**Re:** Flood Relief Works at Graiguenamanagh, Co. Kilkenny & Tinnahinch, Co. Carlow  
Graiguenamanagh, Co. Kilkenny & Tinnahinch, Co. Carlow

I refer to the above-mentioned proposed development which is before the Commission for approval. Please be advised that the Commission, in accordance with section 175(5)(a) of the Planning and Development Act, 2000, as amended, hereby requires you to furnish the following further information in relation to the effects on the environment of the proposed development:

SITE PLAN
SCALE: 1:2000

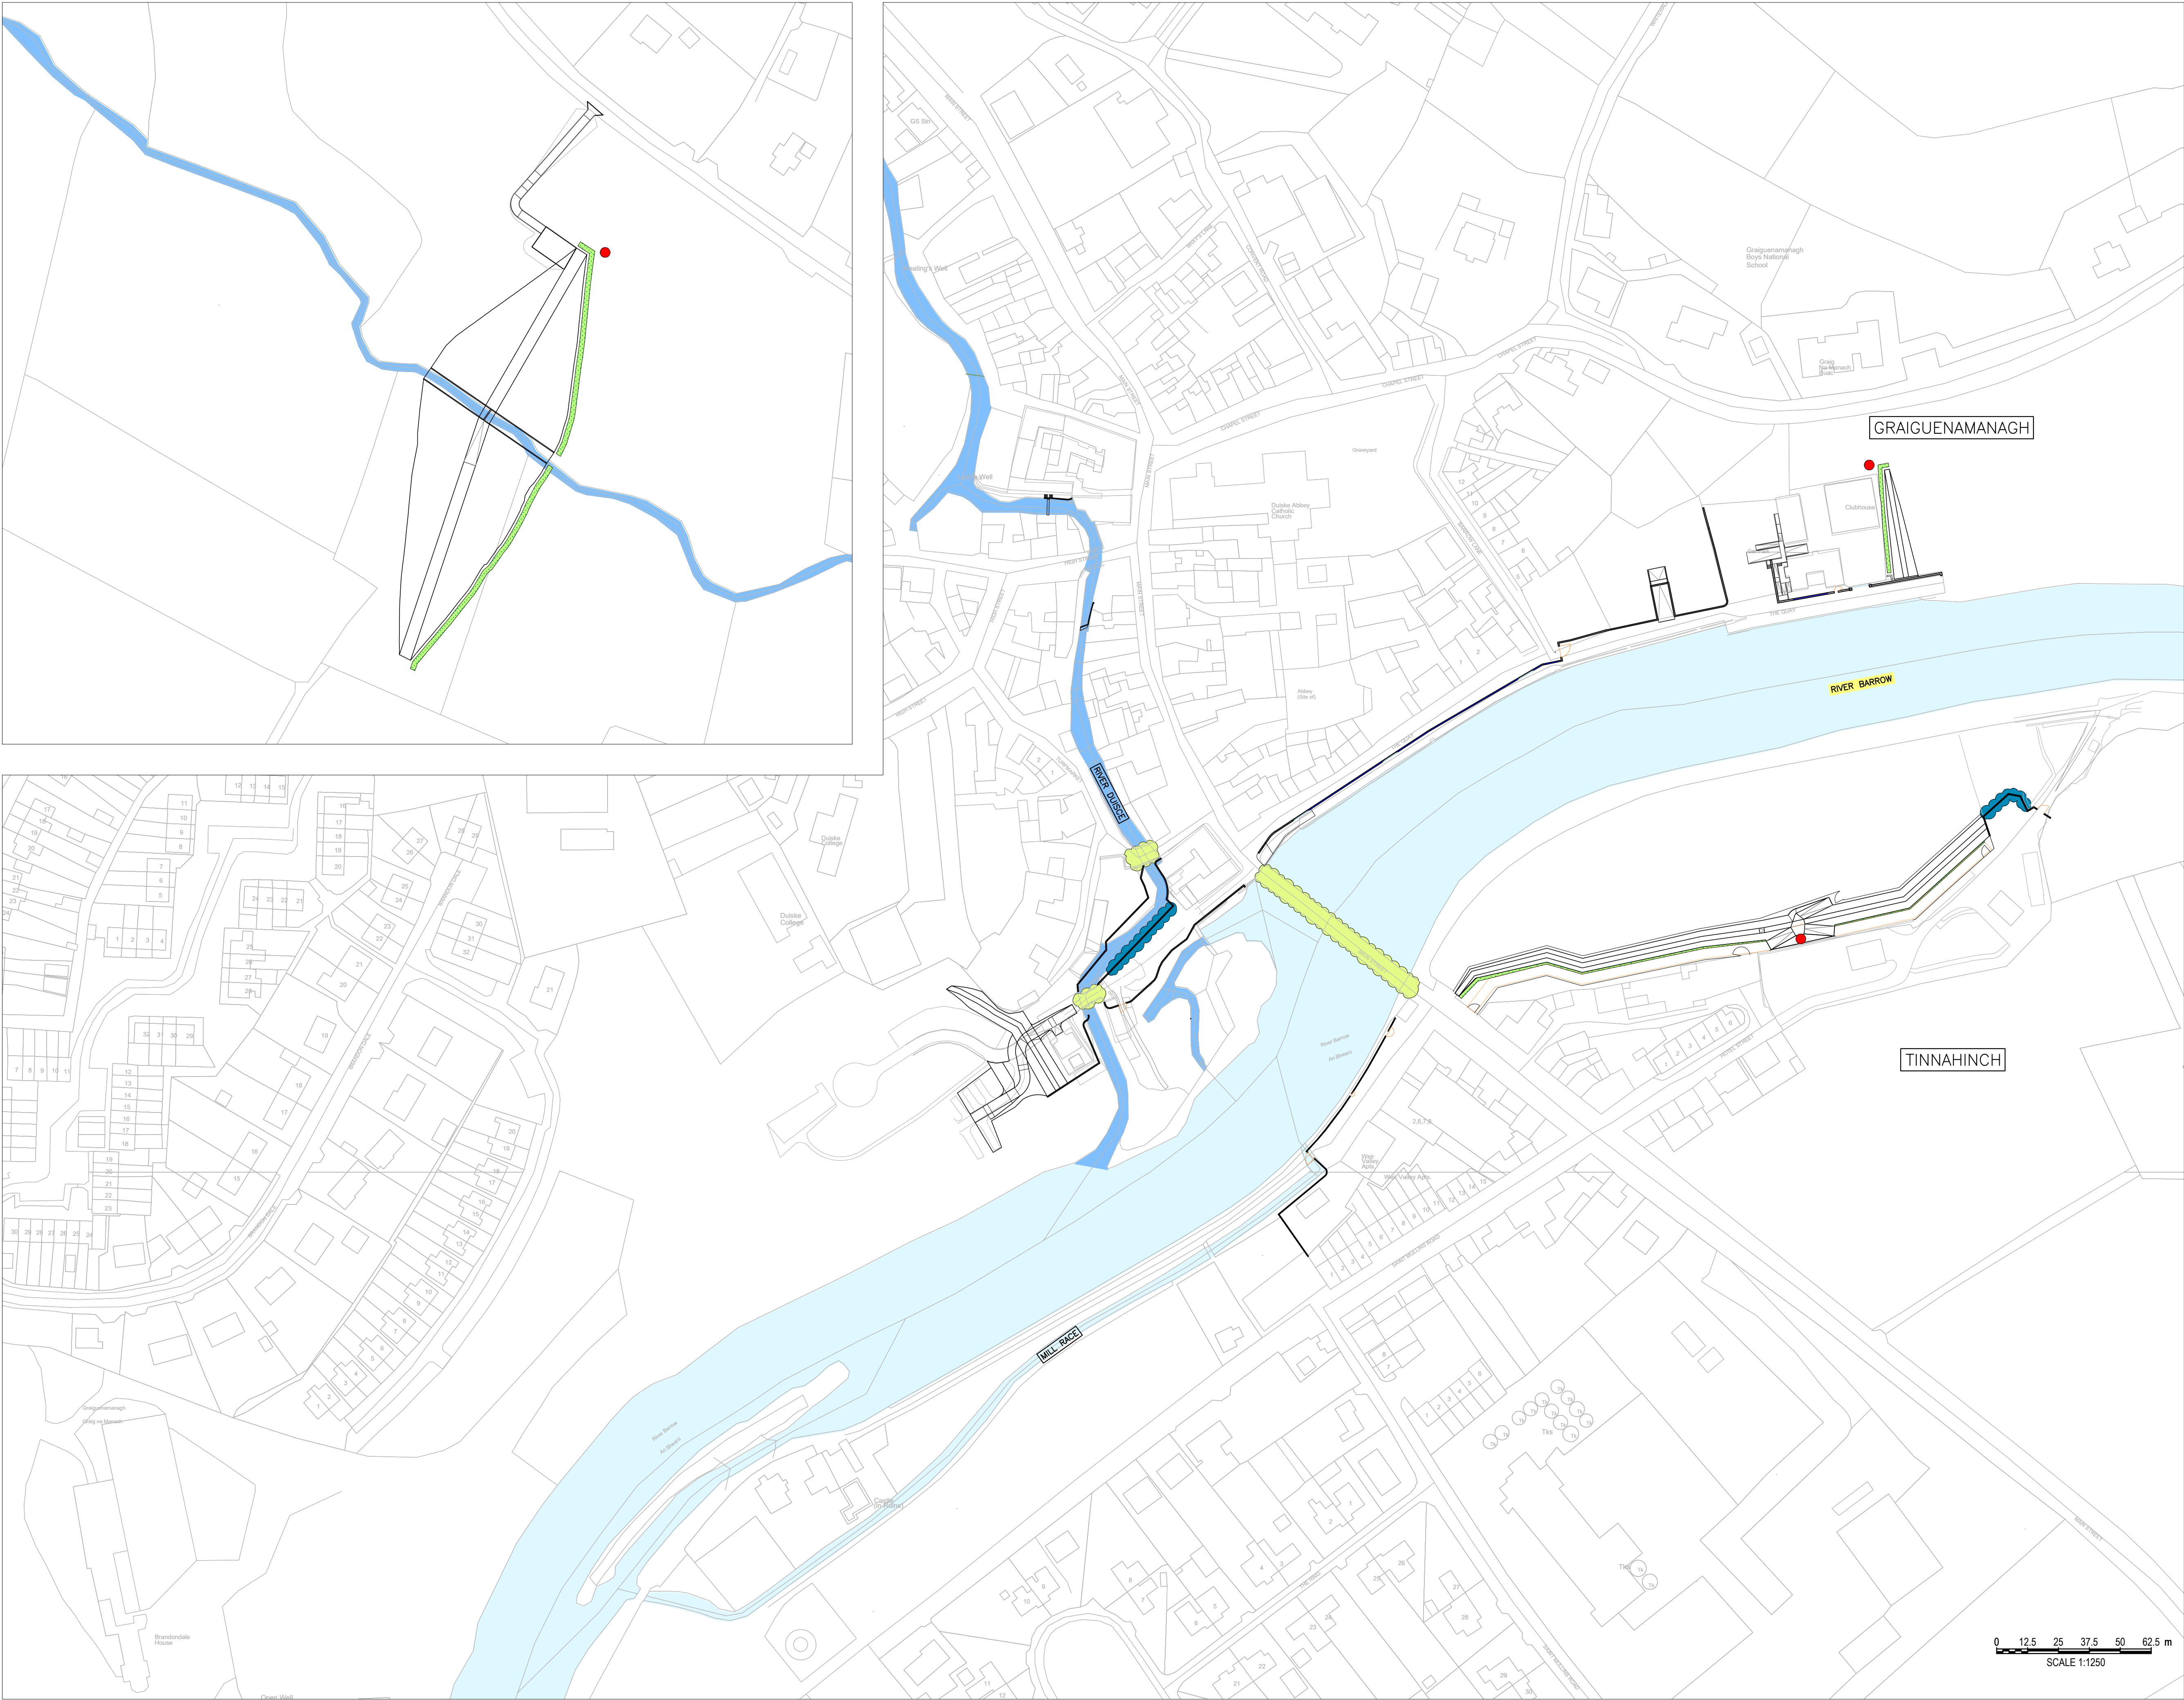
- N. The applicant is requested to review biodiversity enhancement measures set out in section 10.10 of the EIAR and on Drawing No. W3451-AYE-DWG-W-1445 and to submit more substantial measures in this regard reflecting the magnitude and impact of the Scheme. Consideration should be given to the findings and reporting of the Environmental River Enhancement Programme (EREP) in relation to biodiversity enhancement.
